From: [Redacted]
Sent: 17 December 2008 22:05
To: Planning
Subject: S6/2008/2224/MA:Colesdale Farm, 26 Northaw Road West, Northaw

The site is in Green Belt and also the Northaw Common Parkland Landscape Character Area.

Drawing No 10
 ELEVATIONS ON
 A-A & B-B

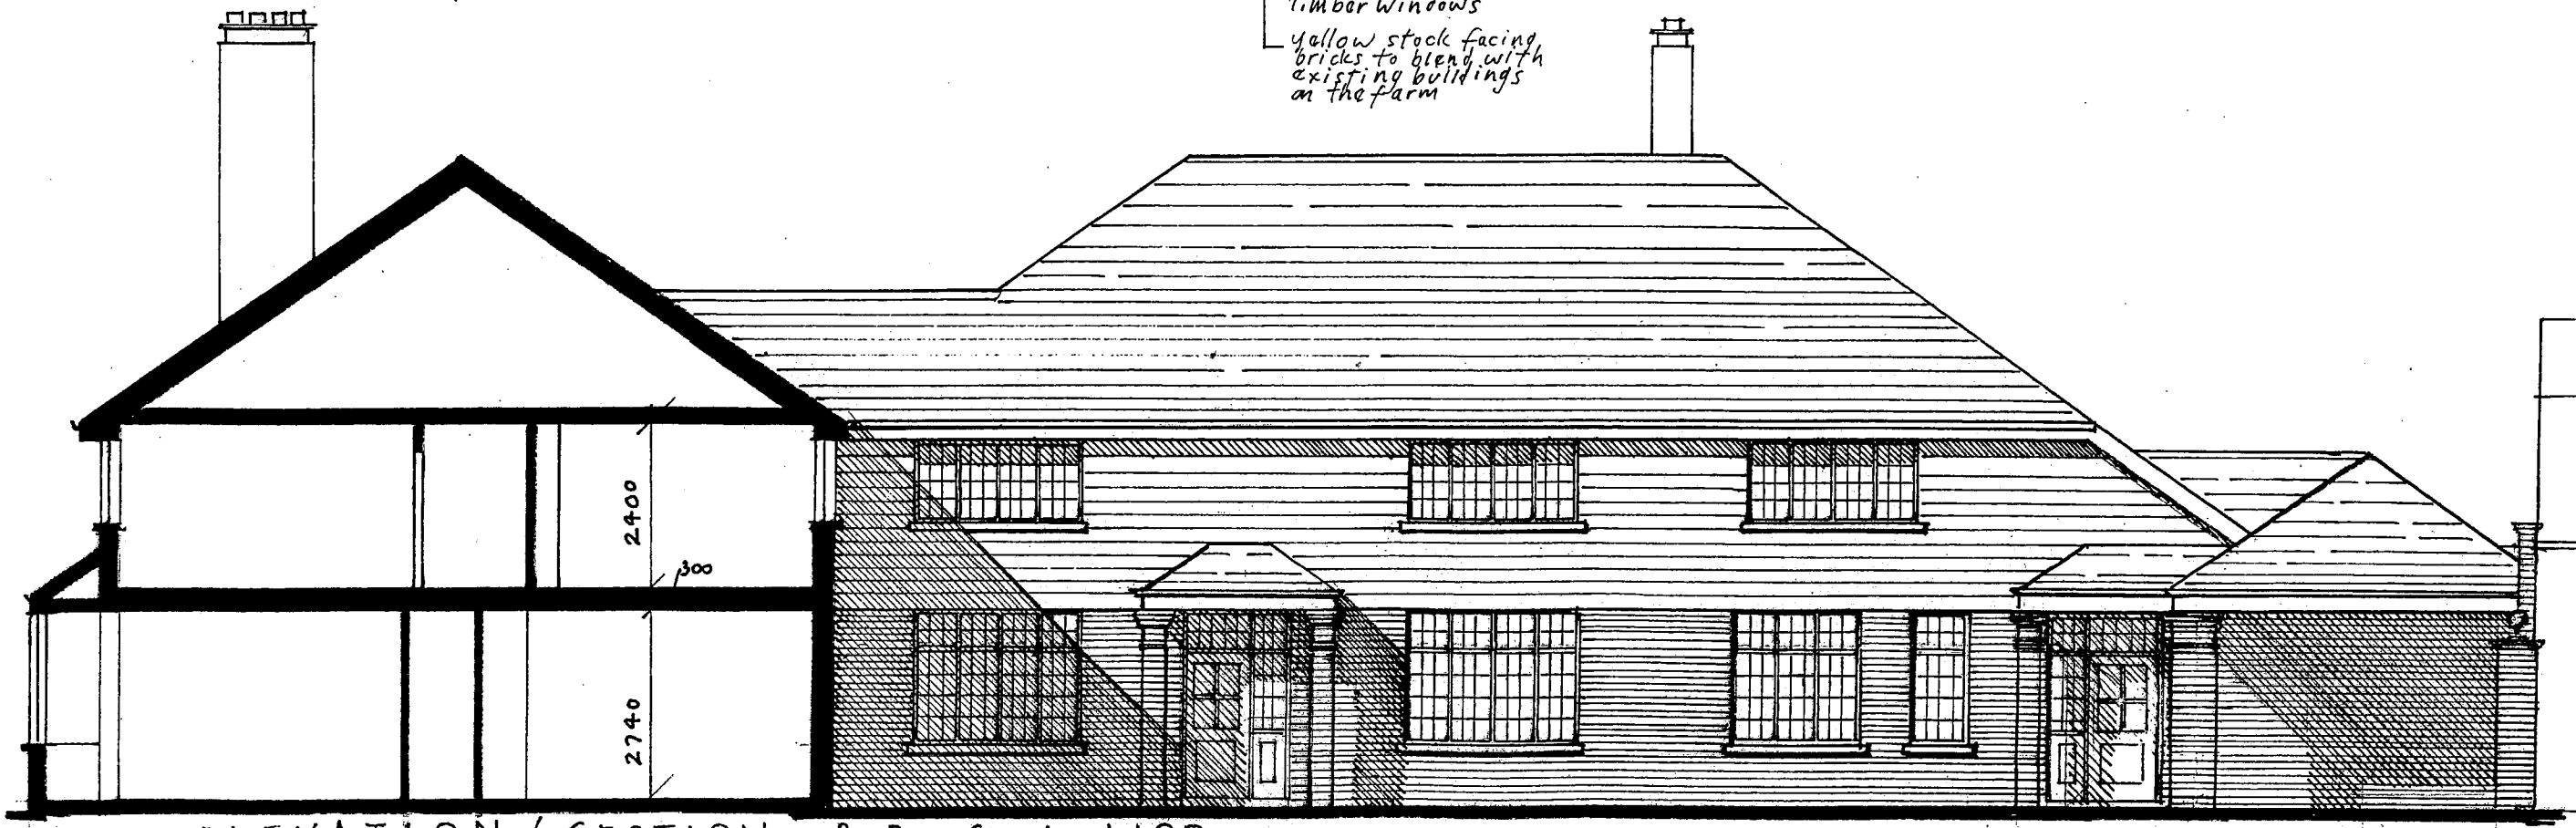
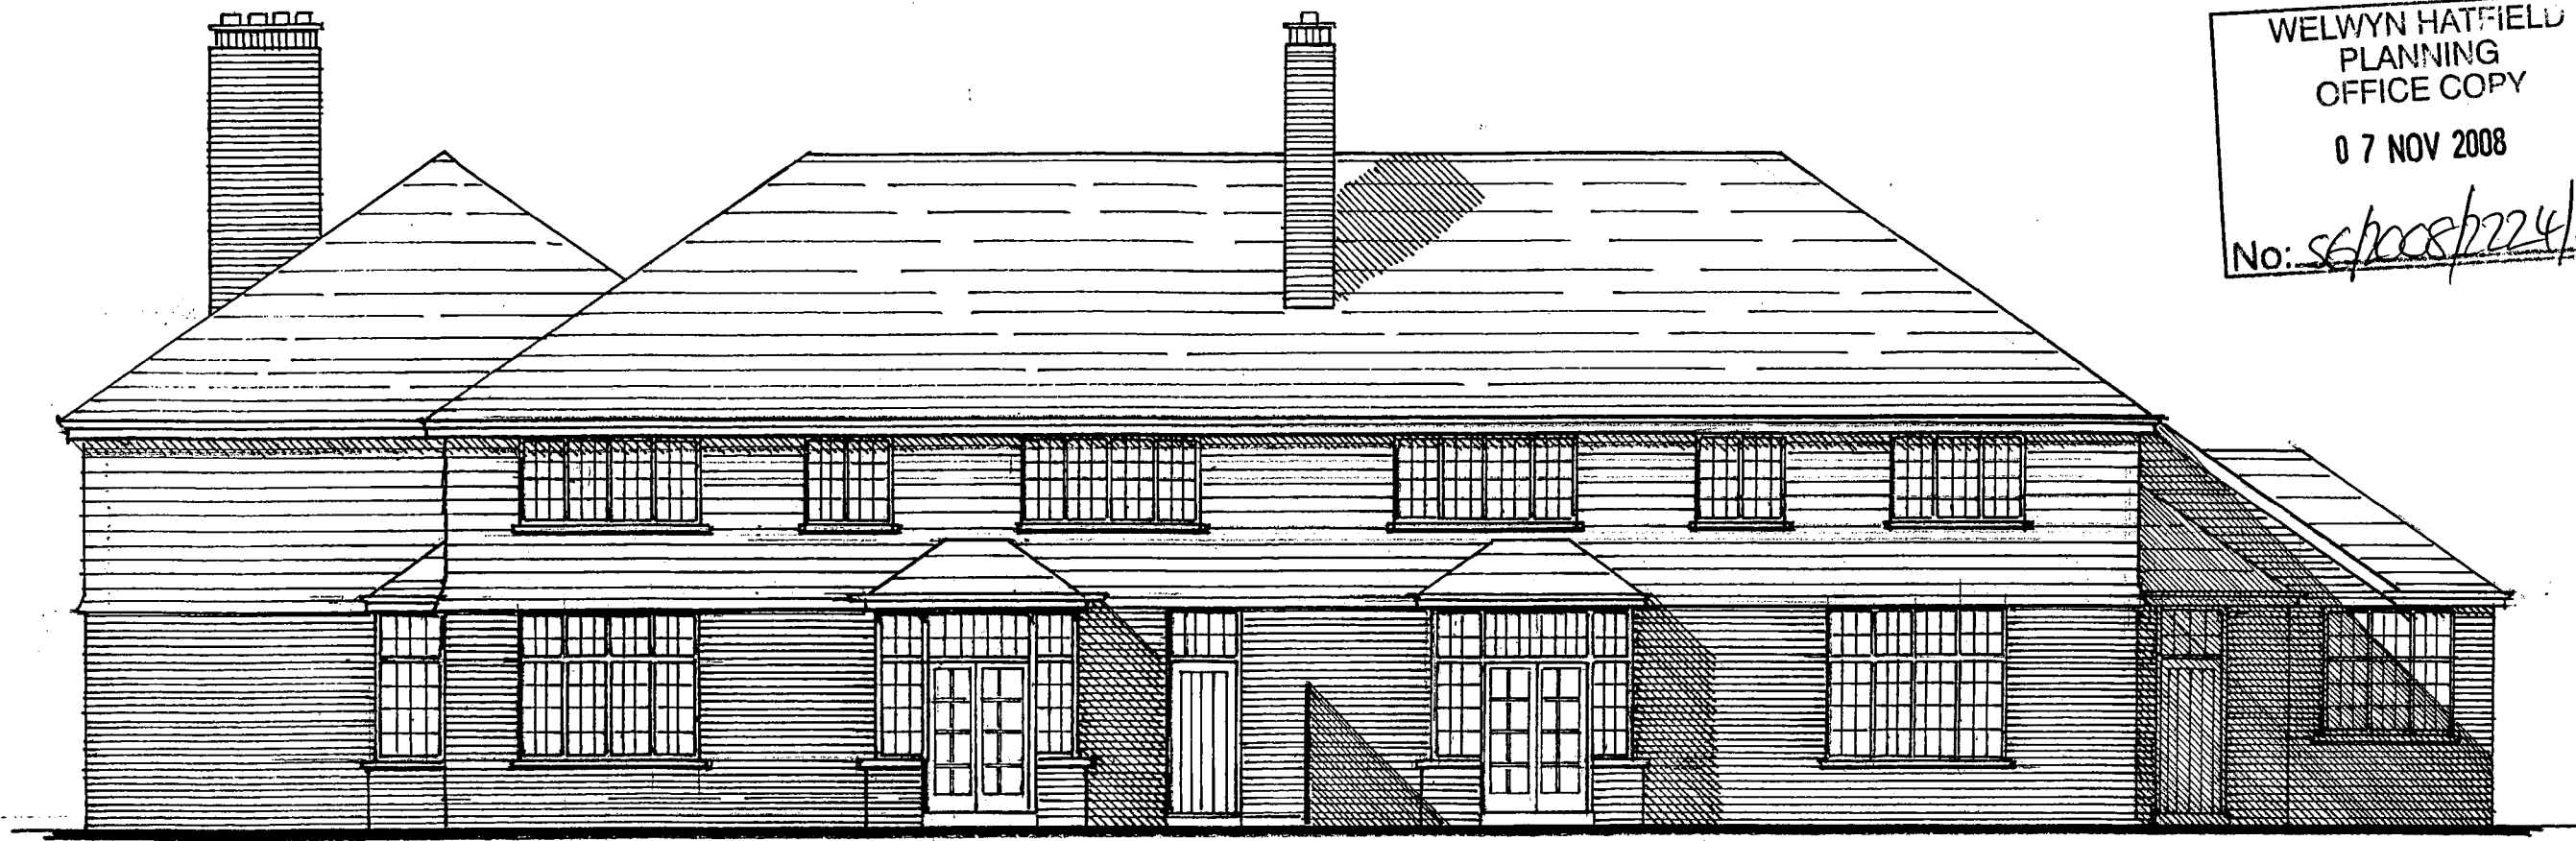
The Group comment that increase in number and height of dwellings in 'the close' for proposed development is retrograde step when compared with approved development – it is detrimental to visual impact, single-storey dwellings would blend in better with scenery.
